19 May 21

RE: SSD-10464 50-52 Phillip Street New Hotel/Residential Building Stage 1 Concept DA

52 PHILLIP ST
APPROX HEIGHT PLANE COMPARISON

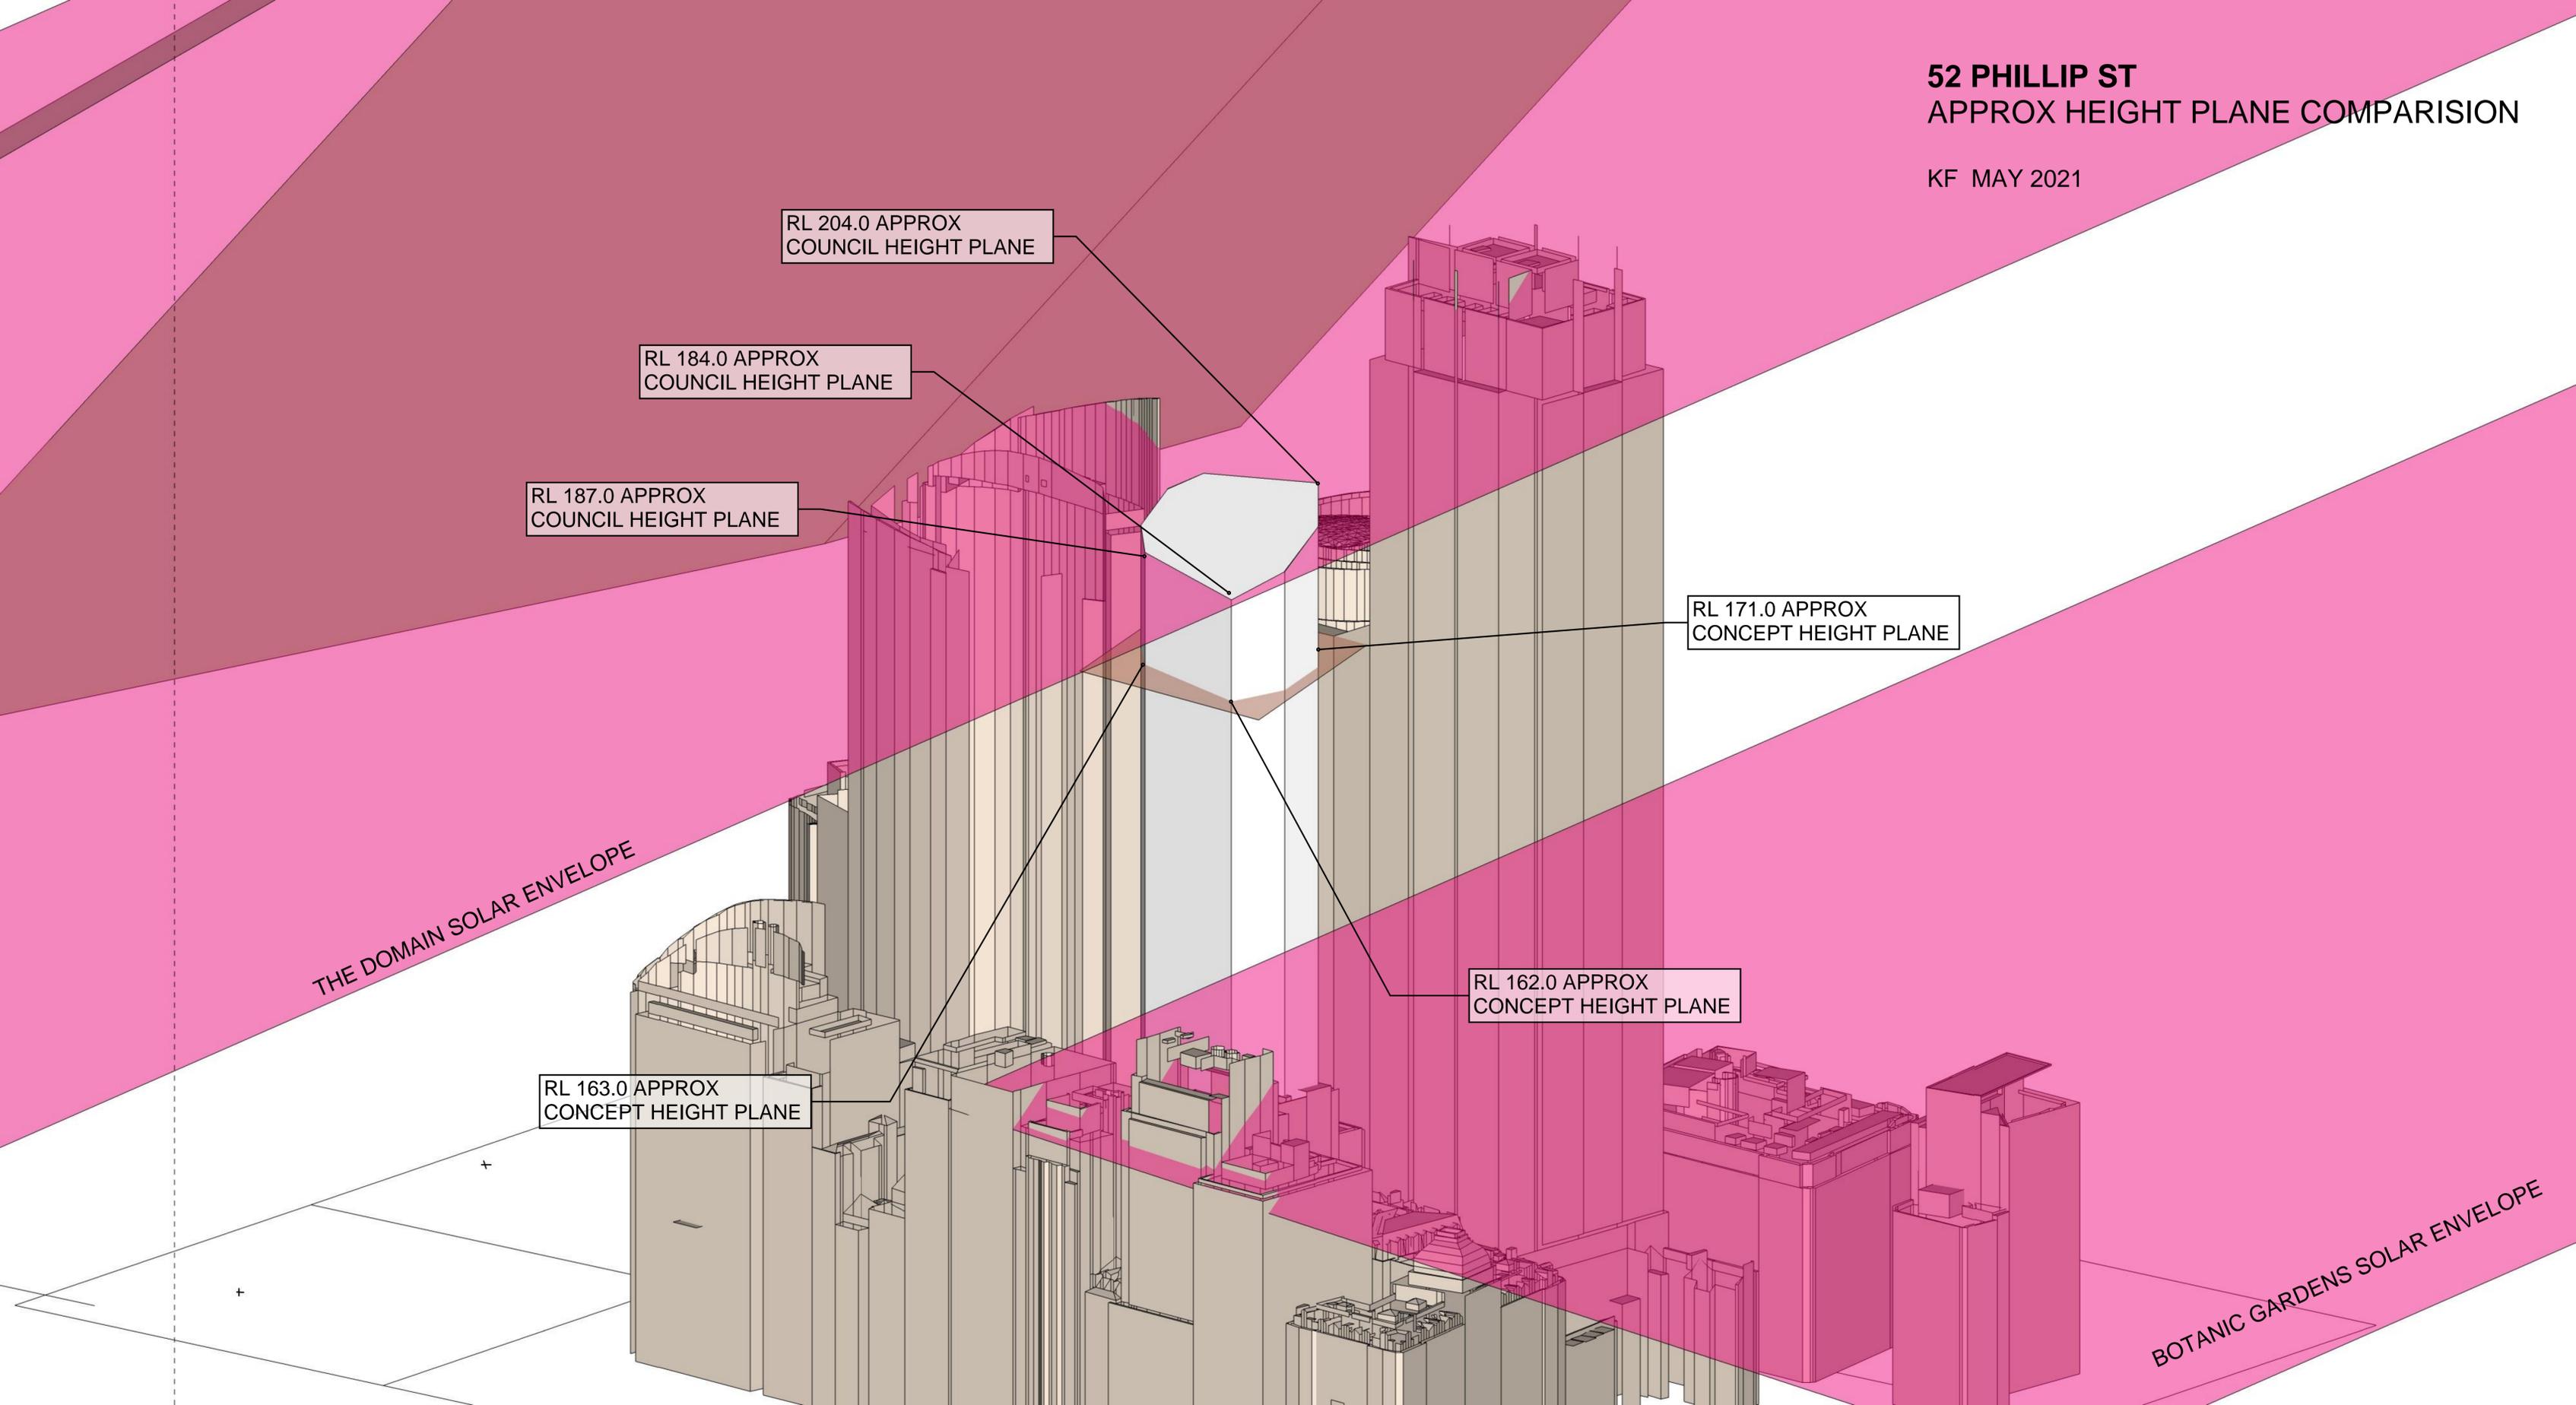
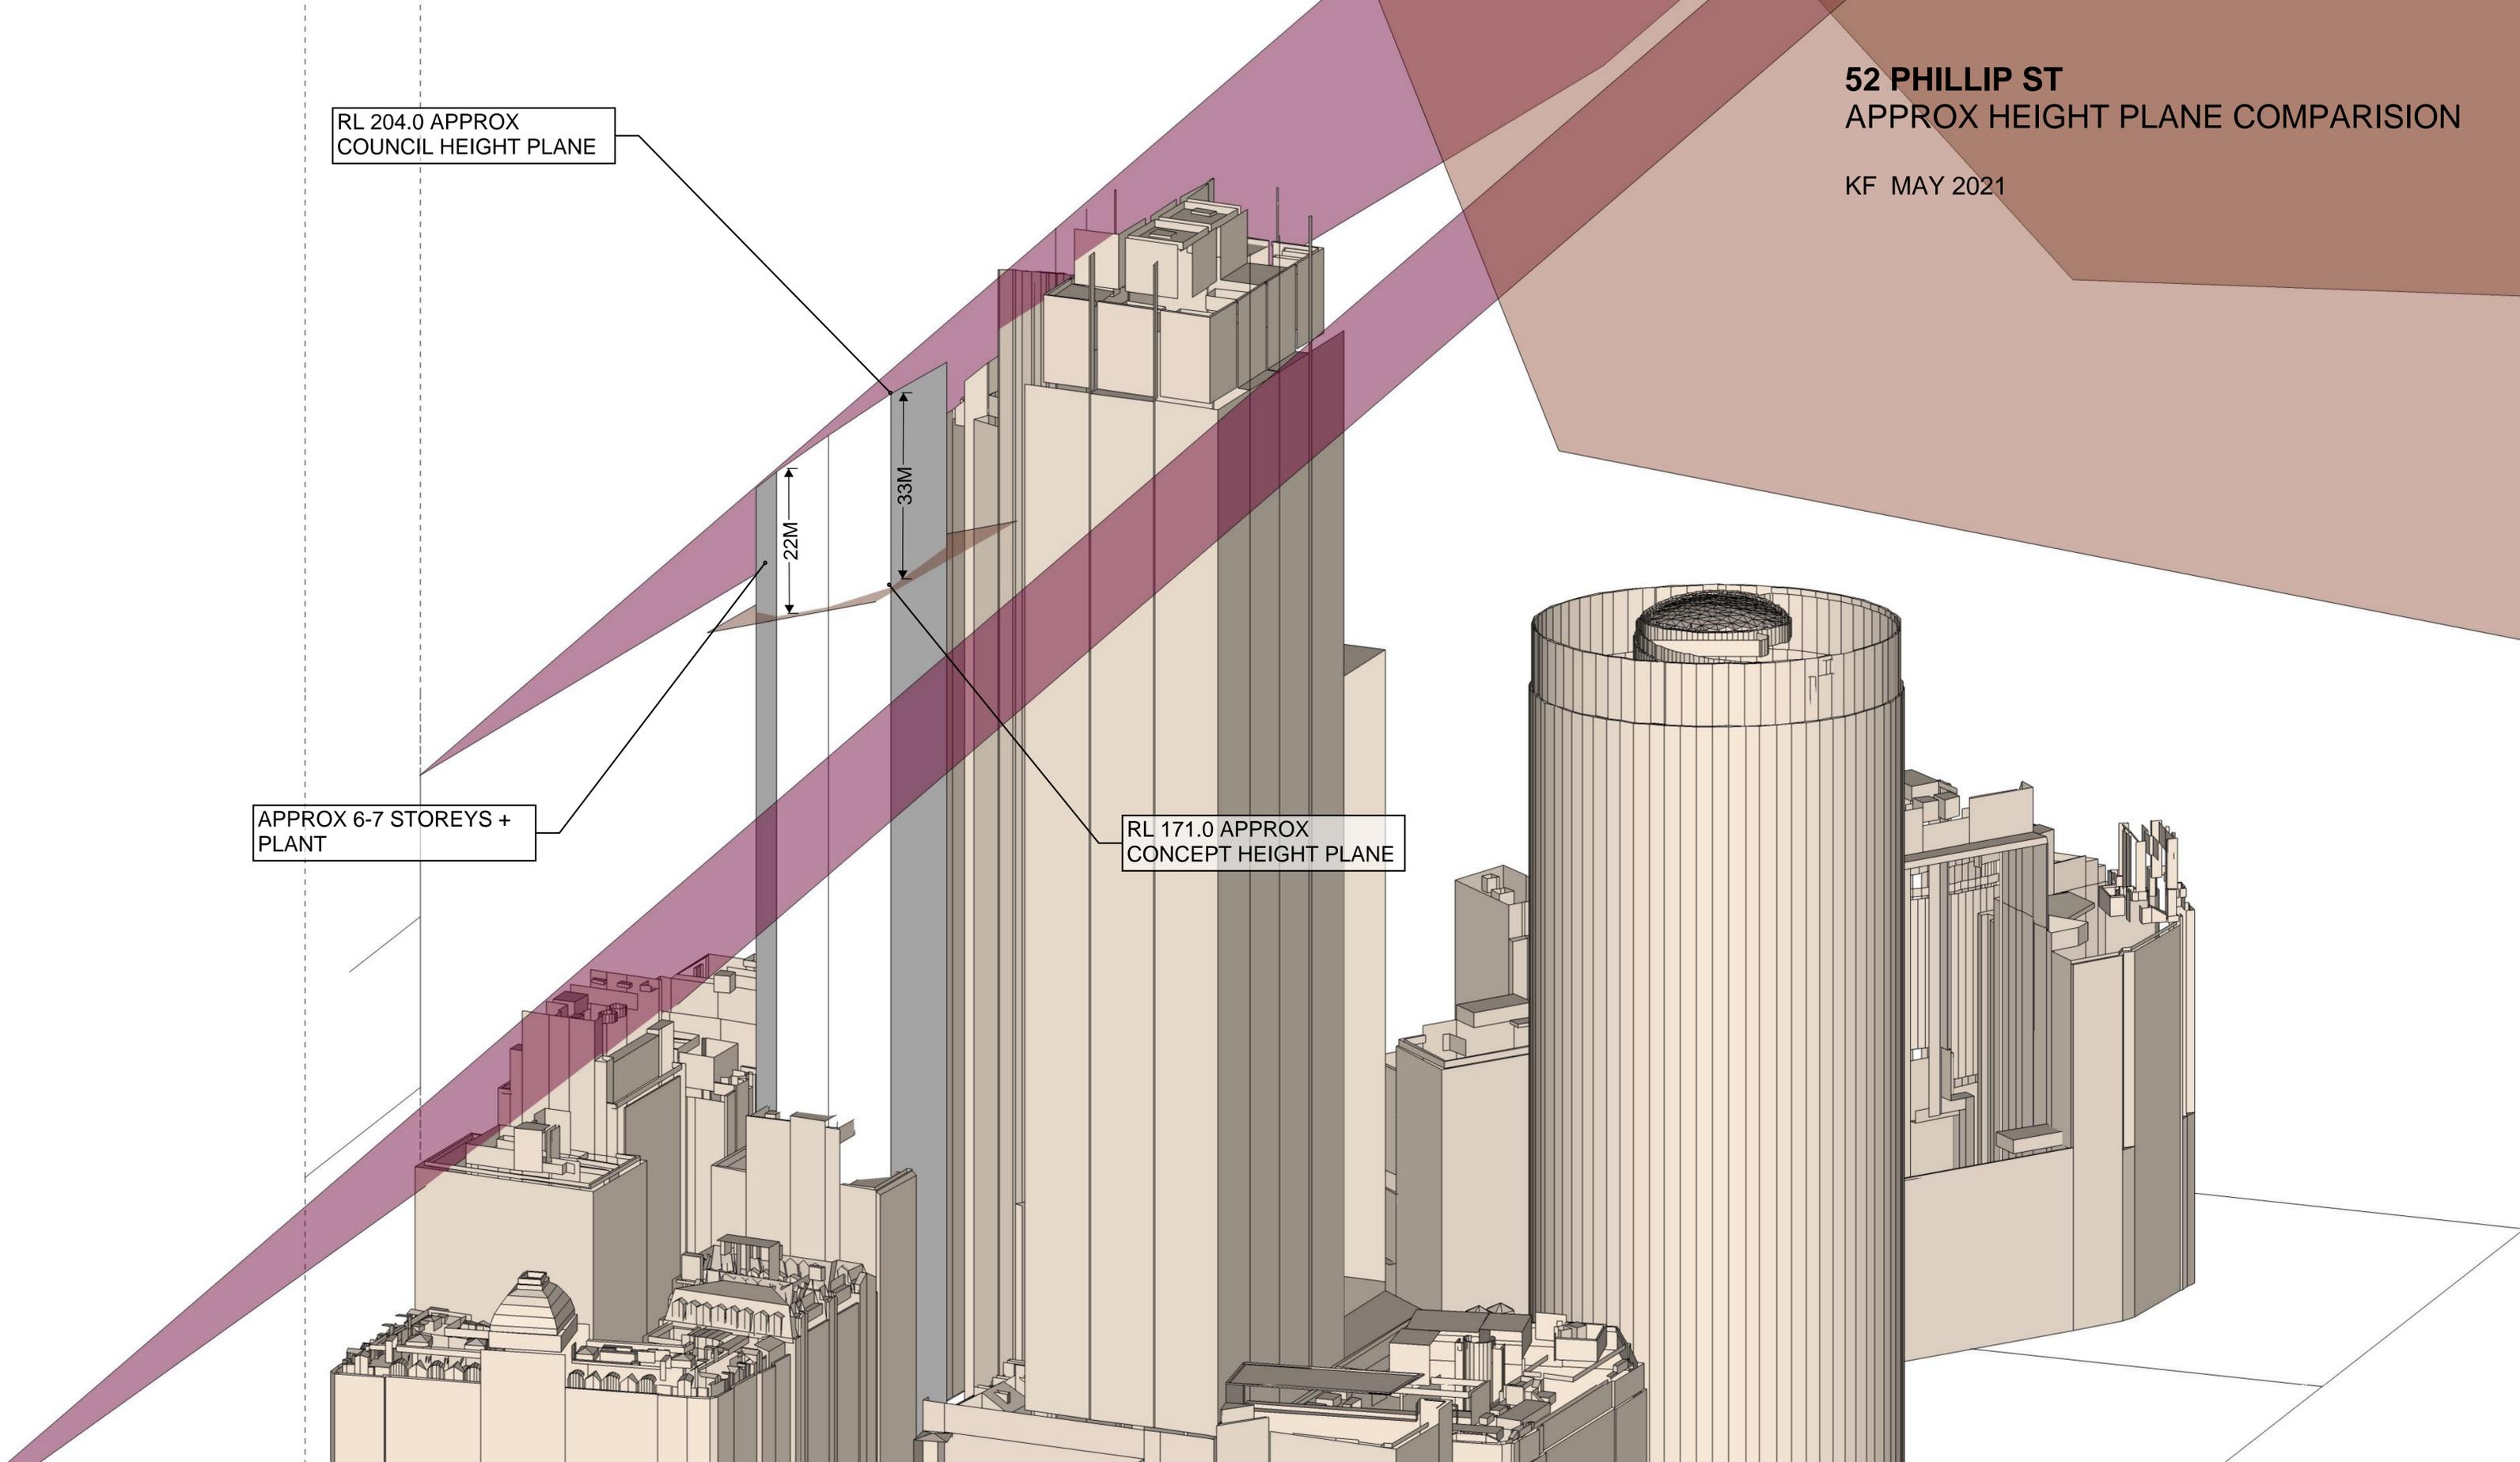
Kann Finch Architects have modelled the sun access planes based on initial extraction file data provided by City of Sydney Council applicable to the site (see **Attachment A**) and confirmed that there are two protrusions above the applicable SAP.

Firstly, the step in the upper level of the building does not align properly with the junction of the two SAPs, resulting in an encroachment that increases from nil in the northwest to 3.5 metres in the southeast, as shown in **Figure 3**.

Secondly, the top of the proposed building envelope extends above the Domain SAP, as shown in **Figure 4**.
